Submission No.			312		
Organisation Name or Name of Submitter			Waterways Ireland		
Item No.	Section Ref.	Page No.	Observation Statement	TII Response	
Ref: Metrolink Railway Order 2022, 24 <sup>th</sup> November 2022					
1	Letter	1	Waterways Ireland owns and maintains the Royal Canal and its towpaths which cross the Metrolink proposal at the Phibsboro area as shown in the Railway Order application. Appropriate short term licensing and longer term property arrangements will be necessary to put in place. It should be noted that Waterways Ireland is a North South Body and as such any property disposals first require Departmental and North South Ministerial Council approvals. All proposed changes should account for the legal protections and the overall concept of the canal as a heritage structure.	Appropriate short term licensing and longer term property arrangements will be in place as necessary via an MoU in advance of the commencement of works. TII is aware of the requirement to notify the North South Ministerial Council of TII's Intention to acquire the lands concerned and are taking step to ensure the necessary approvals are in place.  All proposals will have regard to the concep

**ML1-JAI-EIA-ROUT\_XX-DR-Y-310002– Otter Mitigation Measures at Royal Canal – Cross Section**

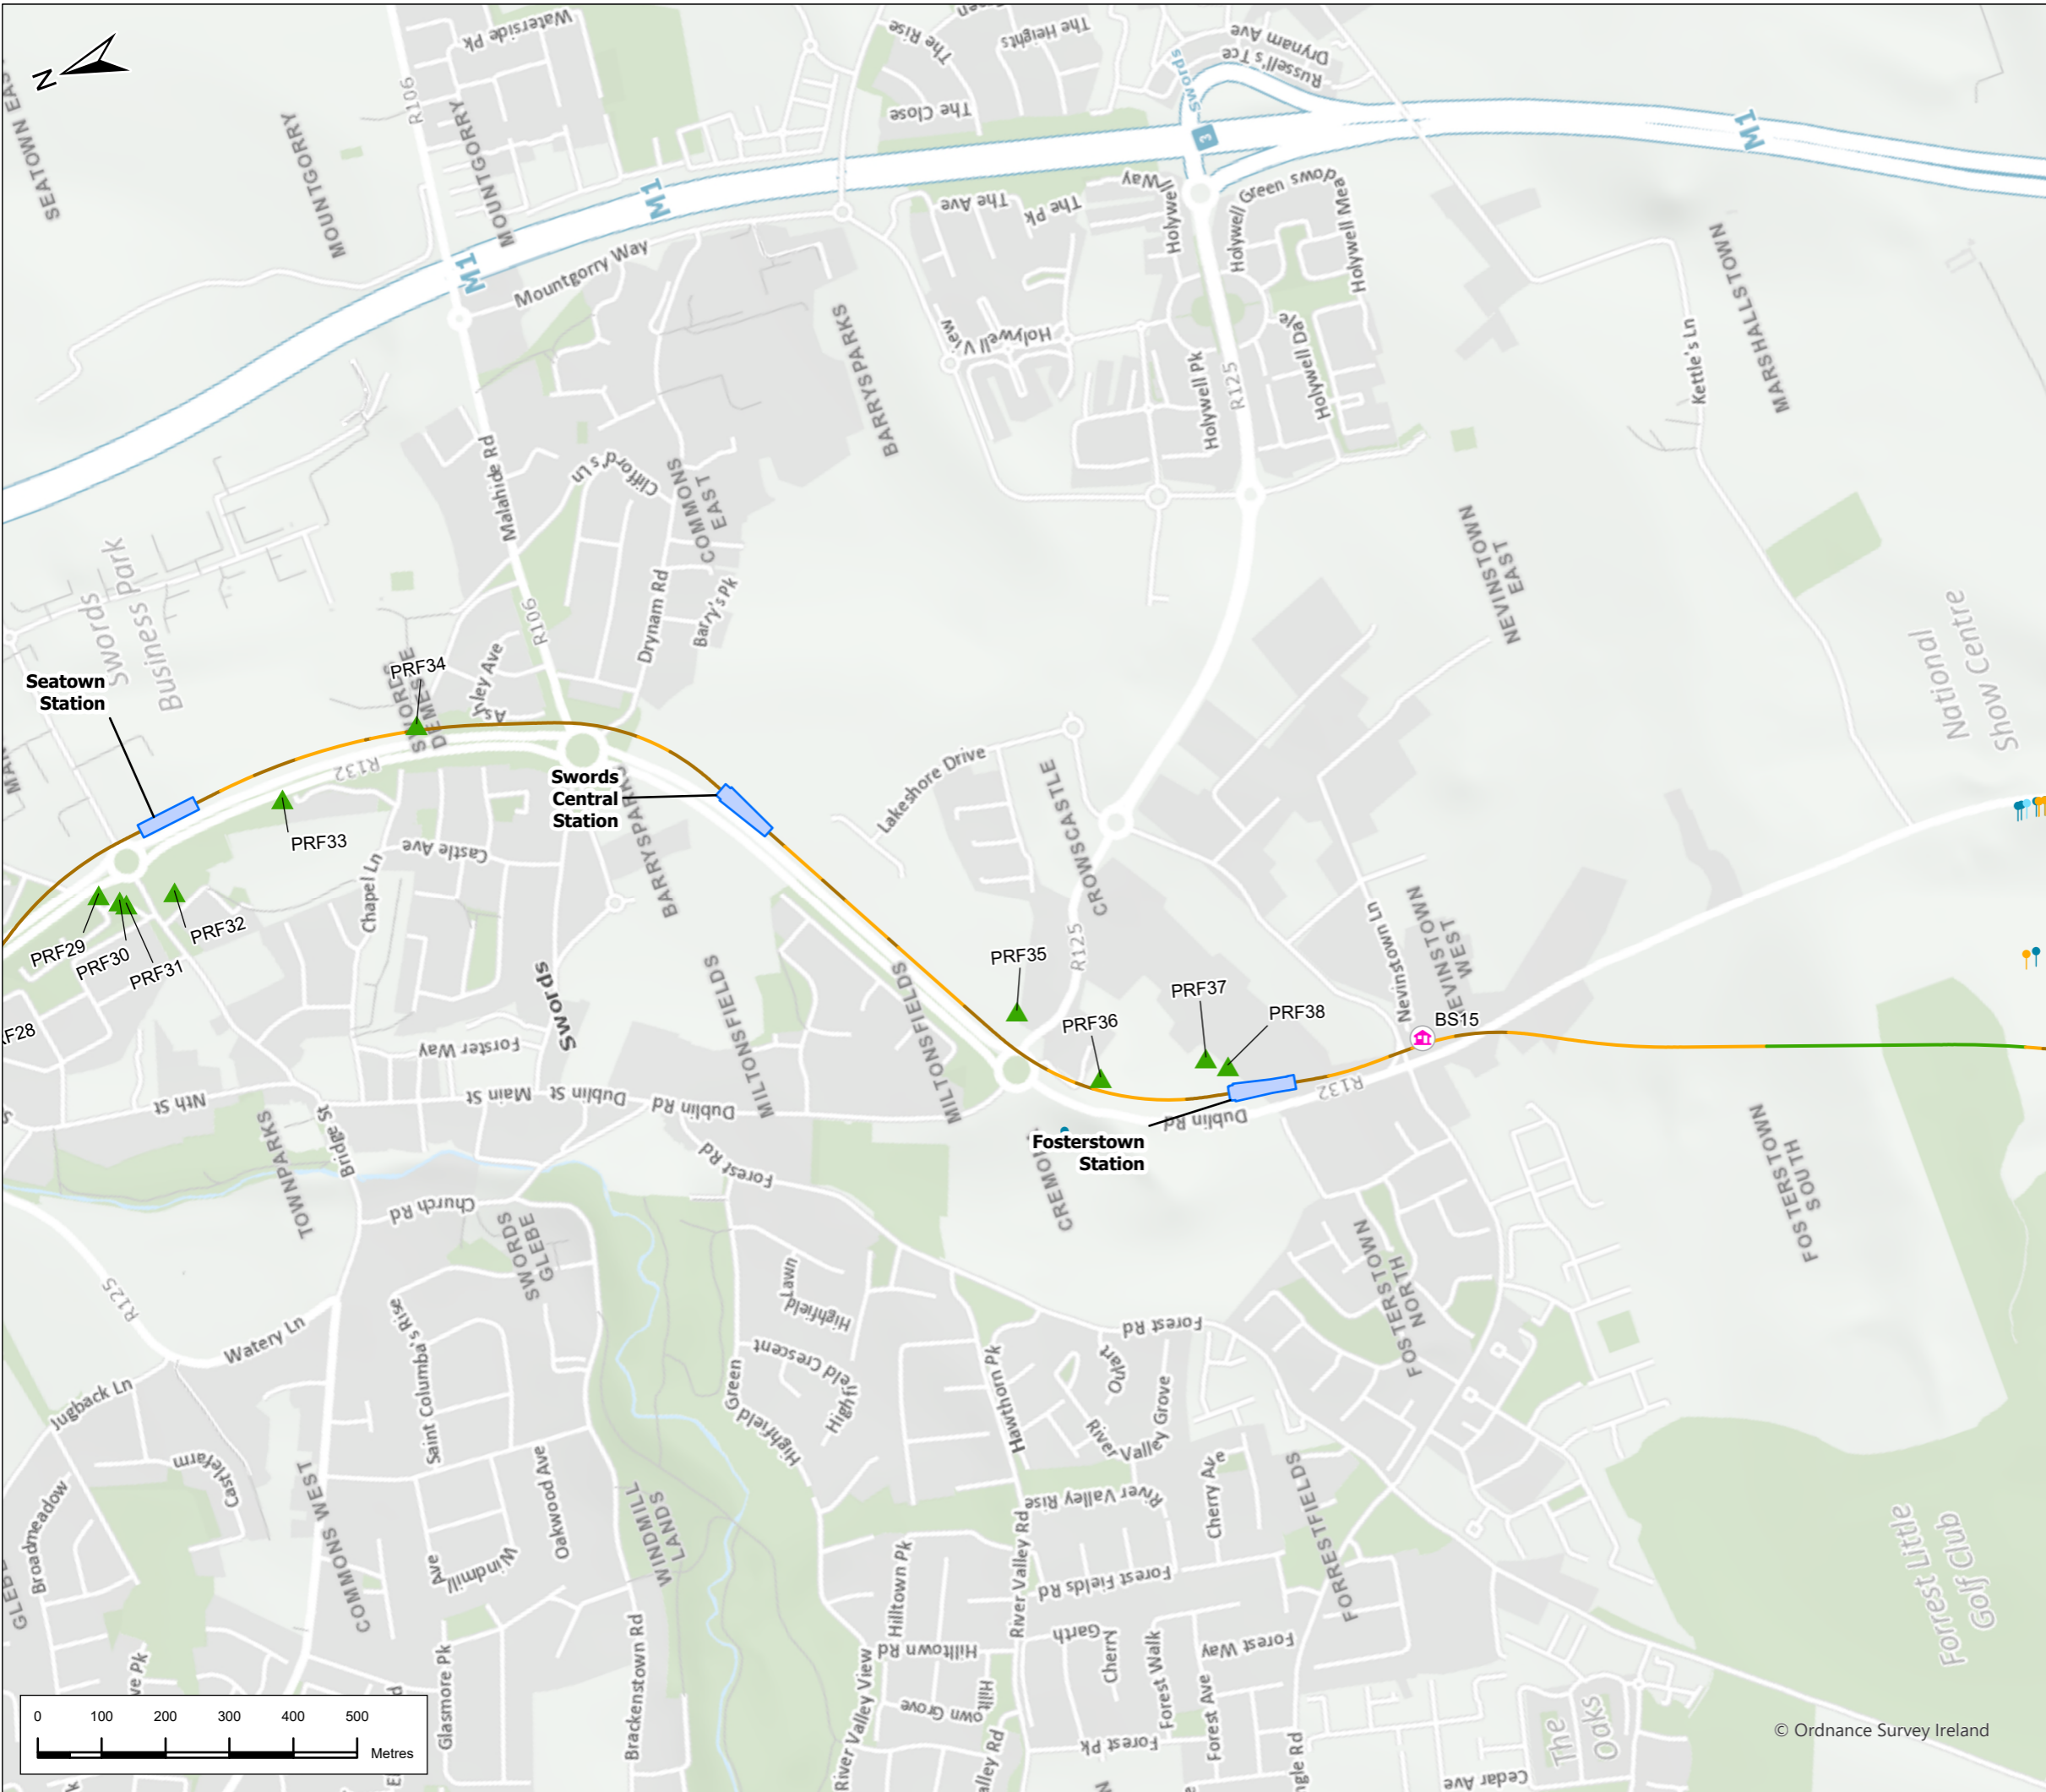
2	Letter	1	The Royal Canal has a proposed designation as a Natural Heritage Area from the Wildlife Act and all proposals must address requirements from this. Canal water quality is measured against the Water Framework Directive standards and is to a very high standard, so no new stormwater discharges are permitted to its waterbody. The canal is an important habitat and all legal environmental procedures must be followed to ensure protection of its flora and fauna, in particular otters and other protected species, both at construction stage and in the permanent works.	<p>EIAR Chapter 18, Hydrology, section 18.4.3.4.3 describes the Royal Canal in terms of its designation as a proposed Natural Heritage Area (pNHA) and acknowledges the requirement for the canal to achieve good "ecological potential". Based on this information, Table 18.15 of the same chapter has identified that the Royal Canal is considered of "very high importance" in this assessment. Construction of Glasnevin Station will temporarily effect the Royal Canal, with a working area to be created in the canal basin. A summary of the proposed mitigation measures associated with the Royal Canal works is provided in the the EIAR Chapter 31, Summaries of the Route Wide Mitigation &amp; Monitoring Proposed, see tables: 31.10 - Biodiversity B3, B14 31.16 - Land take LT5 31.17 - Infrastructure &amp; Utilities - IU4 31.20 - Archaeology &amp; Cultural Heritage, CH73</p> <p>More widely, mitigation measures will minimise impacts on the Royal Canal. The contractor will be required to operate in compliance with a project-specific detailed Construction Environmental Management Plan (CEMP), and all construction sites will be installed with water treatment systems and will be monitored weekly to ensure no impact to the surrounding hydrological environment. With mitigation in place, the residual impact on the Royal Canal will be Imperceptible to Not Significant. TII confirm that there will be no stormwater discharges to the Royal Canal during either the construction or operational phase.</p> <p>EIAR Chapter 15, Biodiversity provides details of the mitigation measures that will be implemented during construction and operation to minimise habitat loss, reduce the potential for impacts on vegetation, reduce the potential for impacts to water quality in receiving watercourses, protect groundwater quantity and quality, and to control and prevent the spread of non native invasive plant species. As otters are listed on Annex II and Annex IV of the EU Habitats Directive they are strictly protected under the Birds and Habitats Regulations. Based on the findings of the field surveys carried out, as there were no otter breeding or resting places, holt or couch sites present within the footprint of the proposed Project boundary, there will not be any loss of holt or couch sites as a result of construction works. As otters could potentially establish new holt or couch sites within the zone of influence of the proposed Project in the future, a pre-construction check of all suitable otter habitats will be required and carried out within 12 months of any construction works commencing. The presence of any new holt/couch sites will be managed in accordance with the Guidelines for the Treatment of Otters prior to the Construction of National Road Schemes.</p>
